# CITY OF ALBUQUERQUE

**Re: Staybridge Suites Meeting Room Addition, 5817 Signal Ave NE,  
Request for Permanent C.O. –Approved  
Engineer's Stamp dated: 05-31-11, (C18/D067)  
Certification dated: 05-01-12**

Based upon the information provided in the Certification received 05-03-12, the above referenced Certification is approved for a release of a Permanent Certificate of Occupancy by Hydrology.

DATE: APRIL 12, 2006

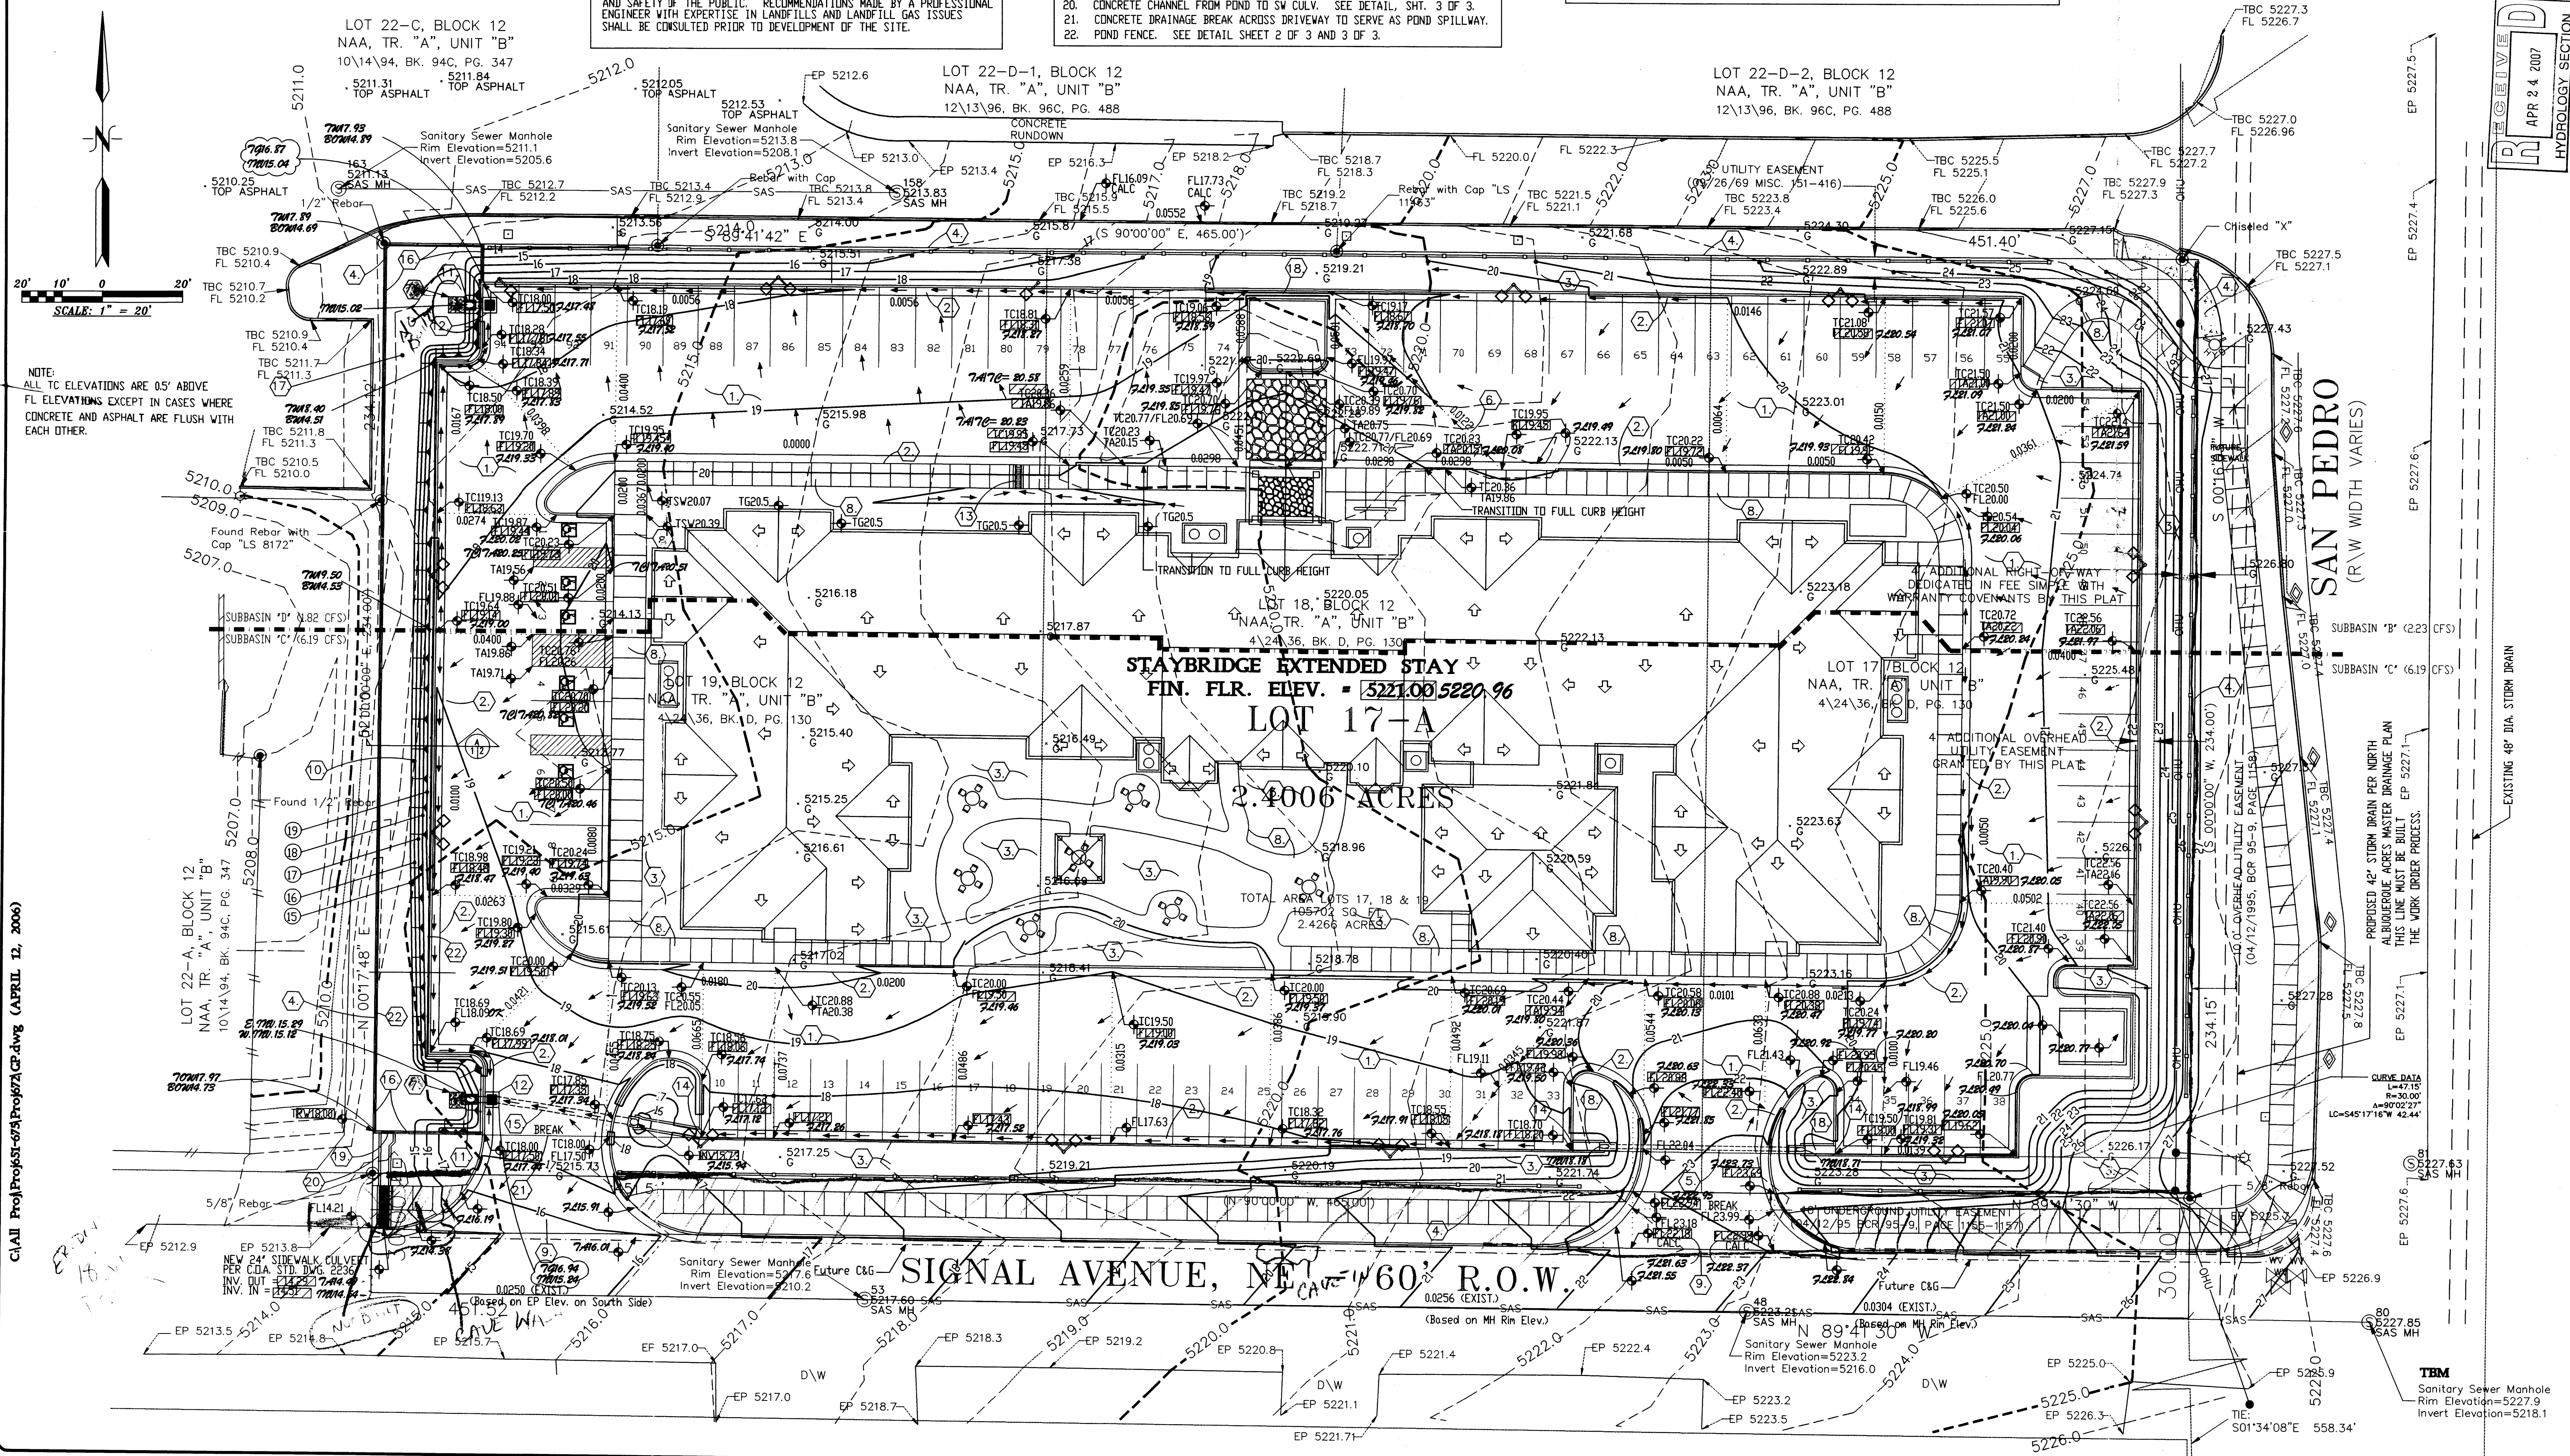
1. The North Albuquerque Acres Master Drainage Plan shows an existing 48" storm drain as well as a proposed 42" storm drain along this section of San Pedro Drive (see attached sheets). Please show this infrastructure, noting that the proposed storm drain must be built through the work order process.

2. More geometric detail must be provided for the retention pond. How is the water guided to the proposed sidewalk culvert? Is there a pond retaining wall approximately 13 feet north of the culvert? How is flow prevented from overflowing in this area?

3. What are the extents of the pond retaining wall? Based on the wall profiles provided, the northern pond retaining wall only extends approximately 20 feet. However, based on the elevations shown, the northern pond retaining wall must be at least 190 feet long to prevent flow from entering

4. All work outside the property lines of this site must be completed through the work order process. Please add a note to this effect.
5. How is the flow guided from the 18" wide curb opening to the next drainage structure(s)? A channel appears to be shown on the plan. Is this the case? If so, please call out these channels and provide a detail.

6. Provide details for the splash pad, alley gutter, sidewalk culvert, and concrete channel (or refer to appropriate City Standards).

1. The proposed 42" and existing 48" storm drain in San Pedro Drive have been shown on the grading and drainage plan.
2. Details have been provided for the pond positive discharge pipes and the concrete channel which will convey the flow to the sidewalk culvert. The pond wall north of the sidewalk is called out by keyed note. I hope that the plan is more clear as to how flow will be directed. It is proposed to use the driveway as the pond overflow.

3. Again, the pond retaining wall has been called out by keyed notes. The north retaining wall extends from the NW corner of the parking lot to the north property line. I hope this is more clearly shown now. The final sentence seems to be unfinished so I hope I answered it adequately.

4. A note has been added regarding all work outside the property line being accomplished by the work order process.
5. For the east driveway, a two foot wide concrete channel has been added to convey the parking lot to the culvert and from the culvert to back into the parking lot and the culvert headwalls have been shown.

6. Details have been shown of all the drainage features mentioned, or standard drawings have been referenced.
